CITY OF ALBUQUERQUE

May 2, 2024

**Re: Event Center
1611 Airtech Ct SE
Site Plan
Architect's Stamp -no date- not for construction (N17D017)**

1 ARCHITECTURAL SITE
SCALE: 1" = 20'-0"

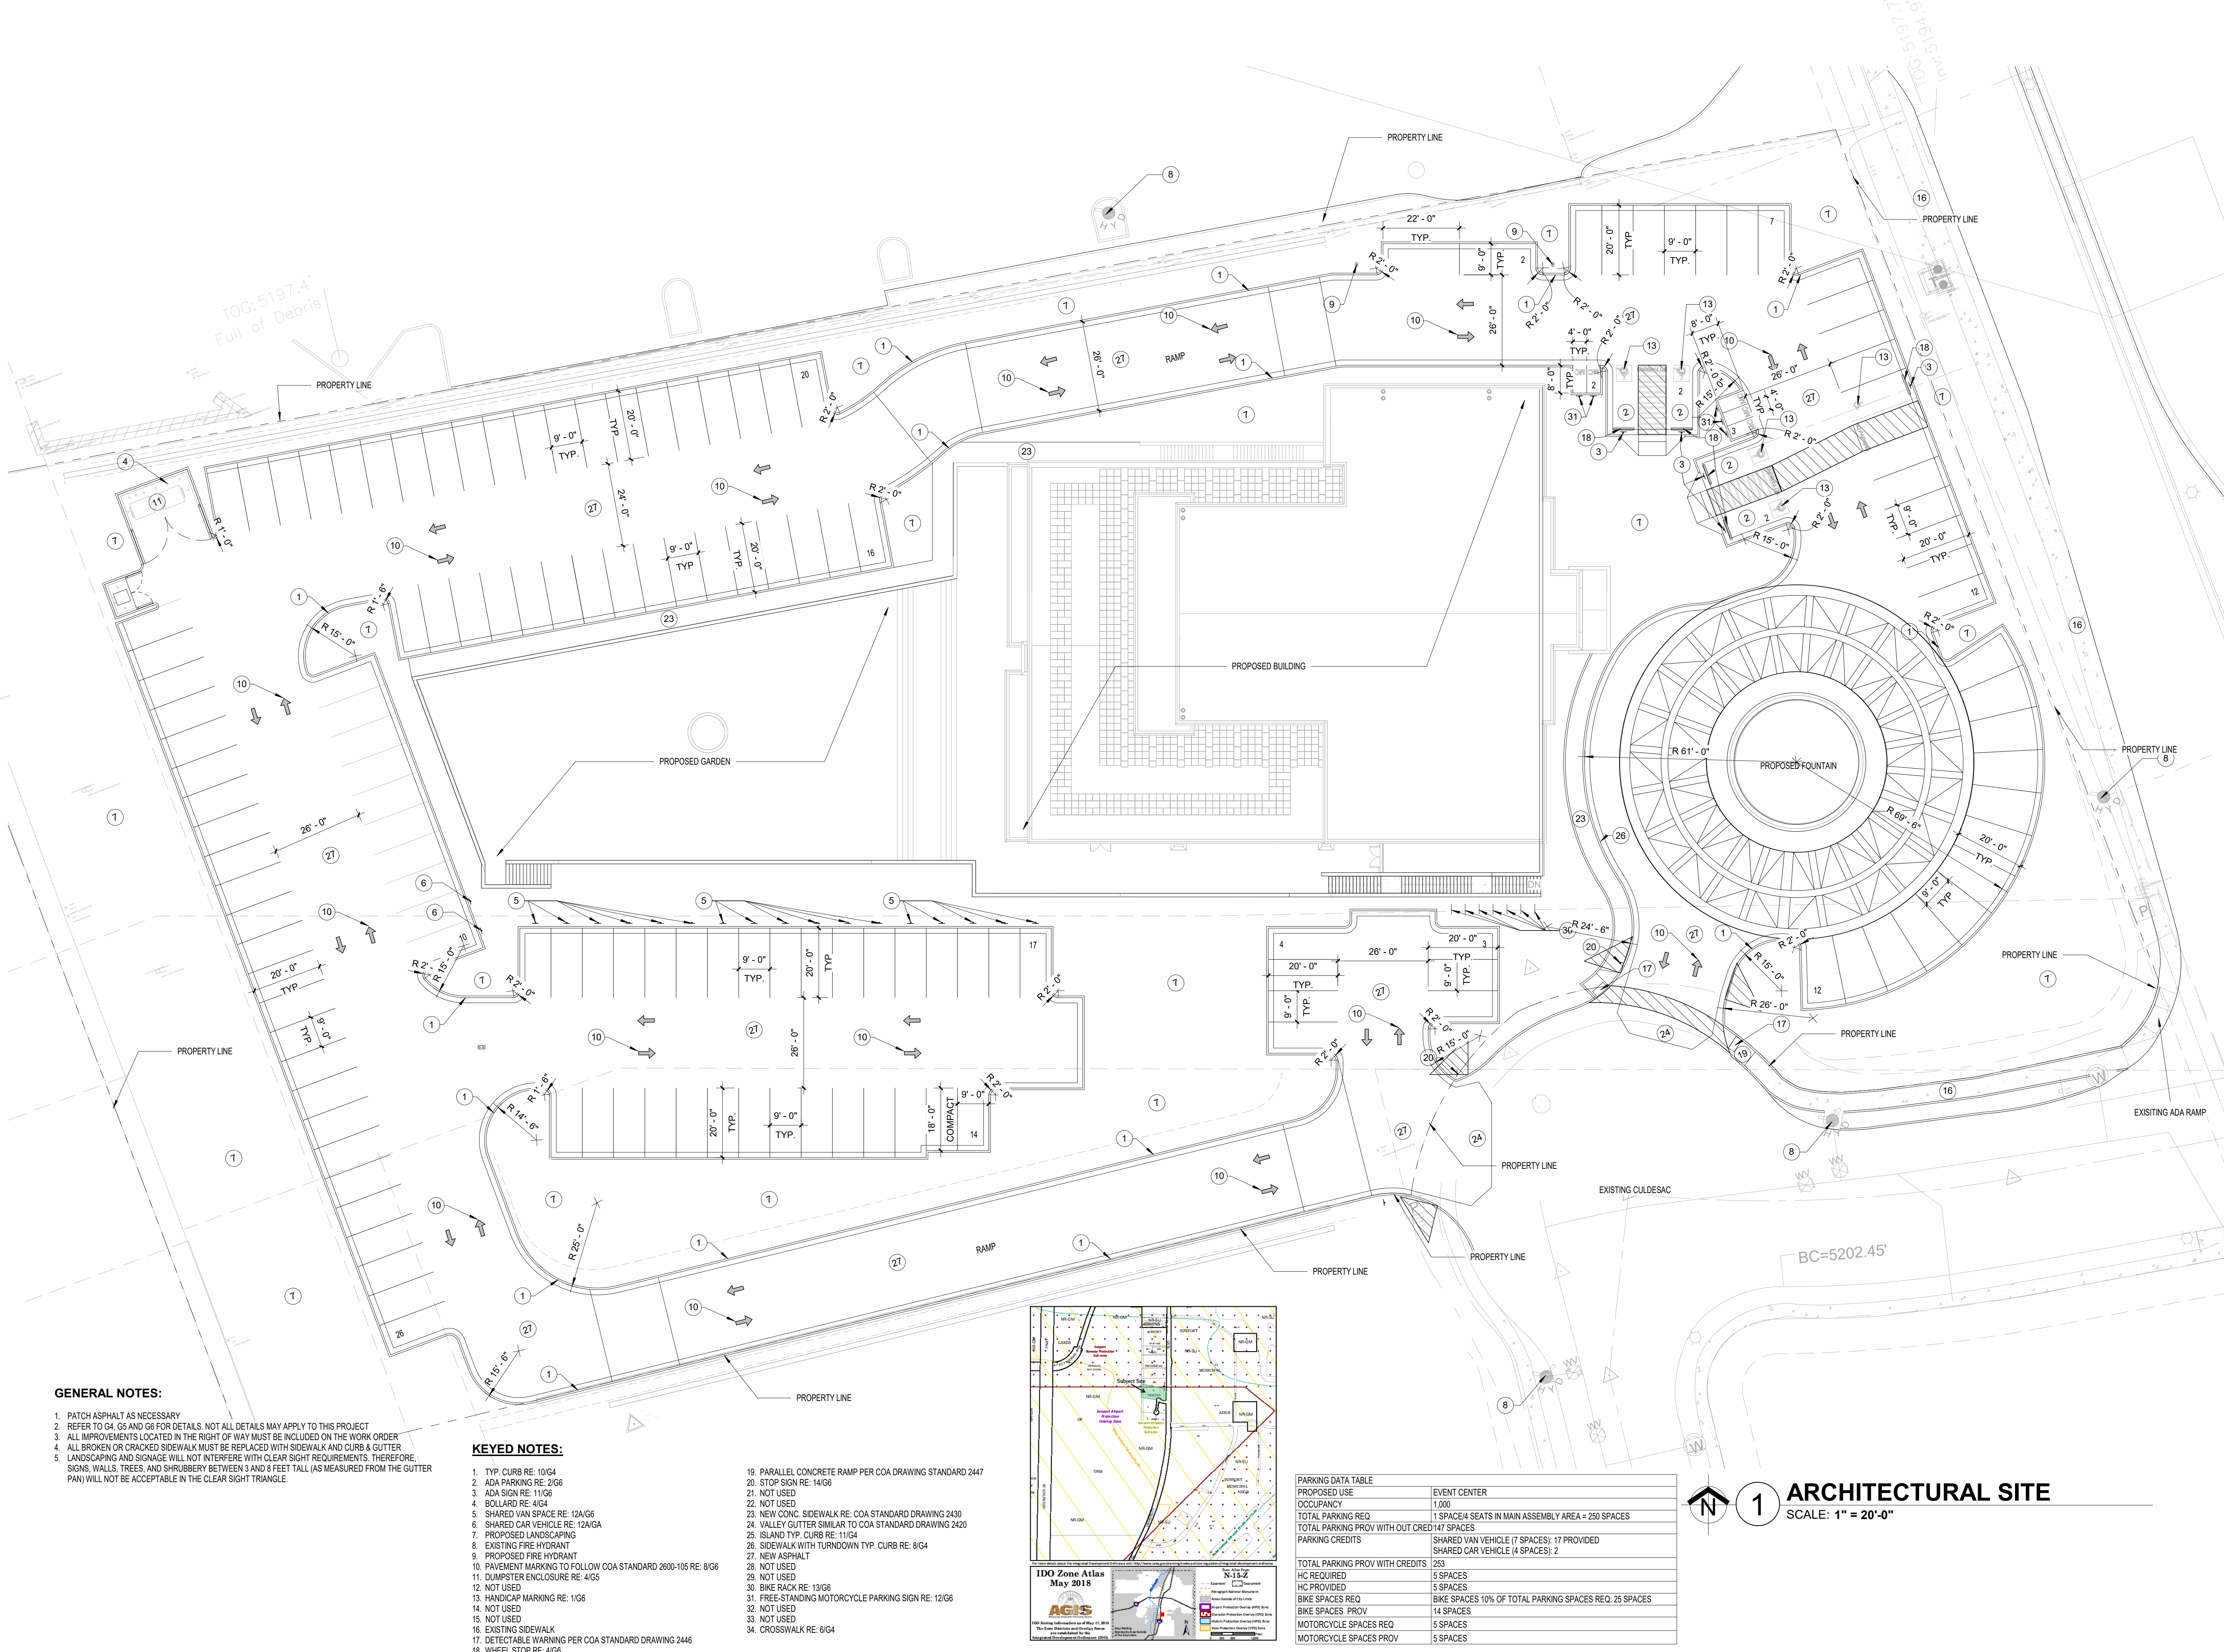
1. There should be 8 accessible parking spaces when the total number of parking spaces provided is 101-300 (2015 NM Accessible Parking Checklist). In addition, 2 van spaces should be provided. Revise the parking table as necessary, add three more accessible parking spaces and show which 2 accessible spaces will be designated as the Van Accessible spaces.

2. Where are the Shared Car Vehicle spaces?
3. The two "Compact" spaces should have "COMPACT" pavement markings in the rear of the space.
4. Show the drainage inlet on the plan that is located in the west/northwest area of the cul-de-sac. The gutter transition begins 5' on either side of the inlet. It appears you may have to relocate the inlet, if approved by Hydrology. This will require a drainage submittal to Hydrology and a Work Order for the relocation. It may also require reconstructing the cul-de-sac to change the low point to the new inlet location.

5. There is a patterned surface around the fountain, which appears to be where vehicles will drive. Provide: material, width of driving surface and inside radius.

6. The patterned surface in comment #2 above, overlaps the curb and gutter in a few places. Probably should reduce the diameter of the patterned surface.

7. Is there a curb or similar (e.g. apron) to prevent drivers from crashing into the fountain?
8. Provide the width of the drop-off lane on the west side of the patterned surface.

9. Please label the front door/main entrance.
10. Provide/show the 6' accessible path from a ROW to the building.
11. The sidewalk and landscape area appear to merge at the building entrance and there is no accessible path from the accessible spaces to the front door.

12. What are the slopes of the “ramps” on the north and south sides of the building. Max is 5%. I noticed the site drops approx. 30 ft from the cul-de-sac to near the west property line.

13. Do the perpendicular lines cross the ramps at the east and west end indicate change in slope? It would help with visibility if the south ramp flattened 50 ft or so from the flowline in the cul-de-sac.

14. It appears you have the 5' minimum keyway distance in the small parking lot south of the building. Please add a dimension.
15. The mini clear sight triangles are drawn too far from the back of sidewalk at the east entrance.

16. Show the existing sidewalk, Keyed Note 16, between the proposed entrances.
17. Provide dimensions for the spacing between the bike racks as well as the distance from the building. A bicycle parking space is 2'x6' (4' between racks) with a 1' clear zone around the perimeter of the bike racks. A detail may be helpful.

18. The proposed western entrance will need ramps on either side of it and please draw the proposed valley gutter.
19. In Detail 11 Sht G6, the bottom of the lowest sign (e.g. “Van Accessible”) is to be 60”/5’.
